MEMORANDUM

TO: Caitlin Cameron, Planner
FROM: David Senus, P.E. & Ashley Auger, E.I.T.
DATE: May 29, 2014
RE: 185 Fore Street, Preliminary Level III Site Plan Application

Woodard & Curran has reviewed the Preliminary Level III Site Plan Application for the proposed mixed-use building located at 185 Fore Street in Portland, Maine. The project consists of constructing a four story building with retail uses on the ground floor and six residential units on the upper floors.

(A) BRICK SIDEWALK DETAIL
N.T.S.

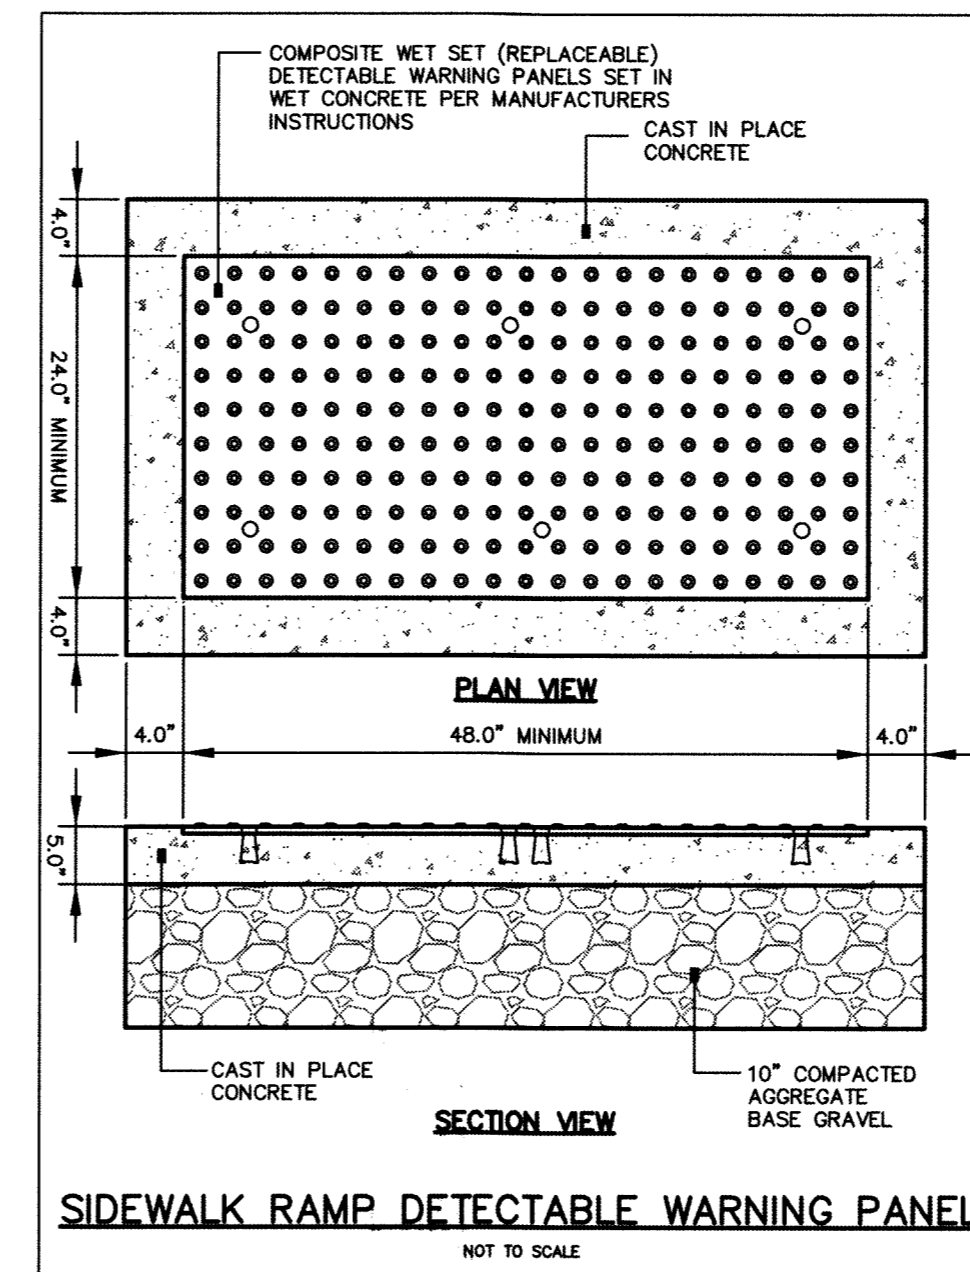
- 6) The Brick Sidewalk, Vertical Granite Curb, and Typical Trench Details should be prepared in accordance with Figures I -10, I-16, and II-12, respectively, of the City of Portland Technical Manual for work within the City Right-of-Way.

(F) BARRIER FREE RAMP DETAILS
N.T.S.

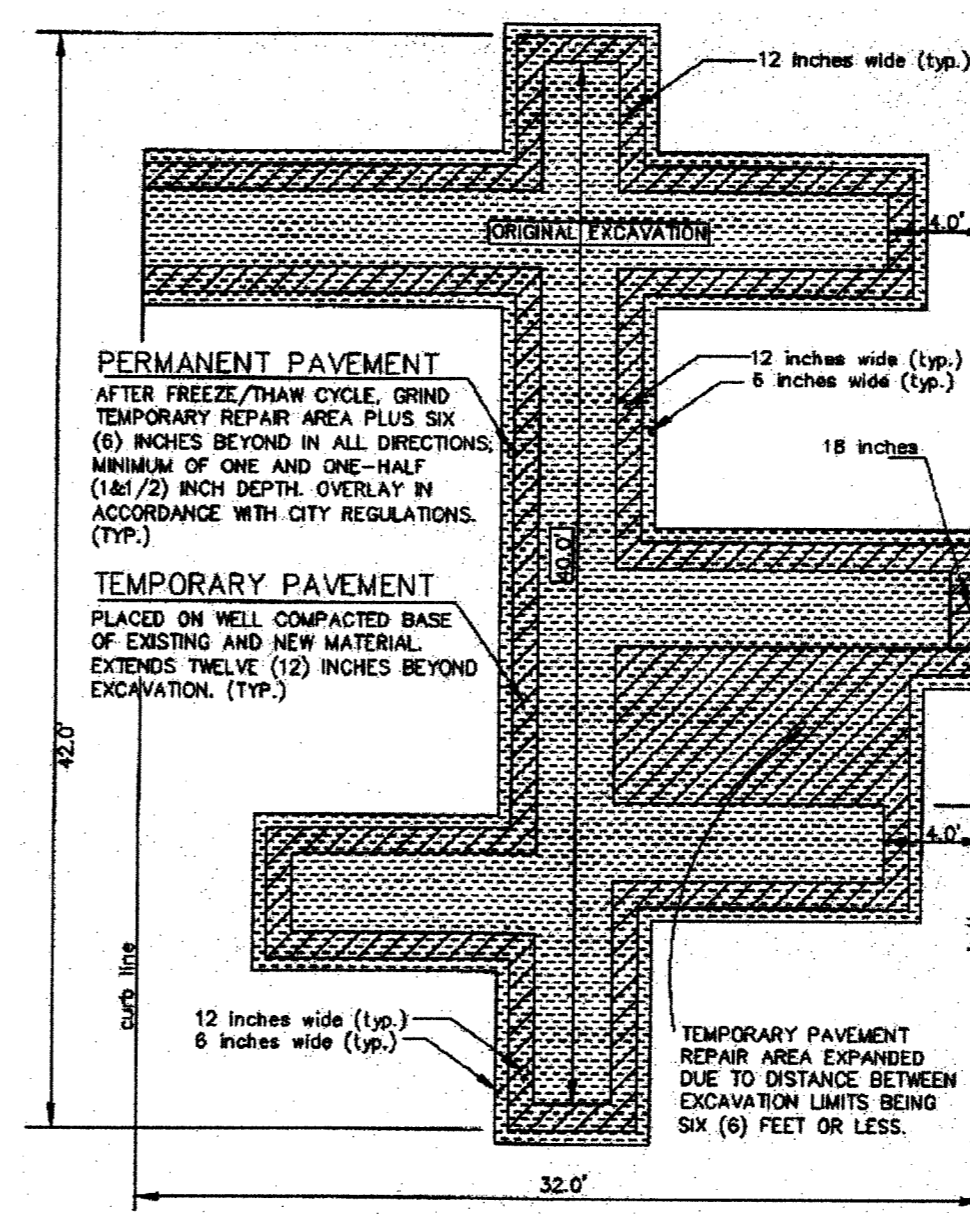
- 7) The Barrier Free Ramp Detail contains a note referencing the Town of Scarborough Right-of-Way; the Applicant should modify this note.
- 8) Multiple notes on the Utility Plan (C-5) refer to an Site Electrical Plan (E1.01), a copy of which has not been received with this Preliminary Application.
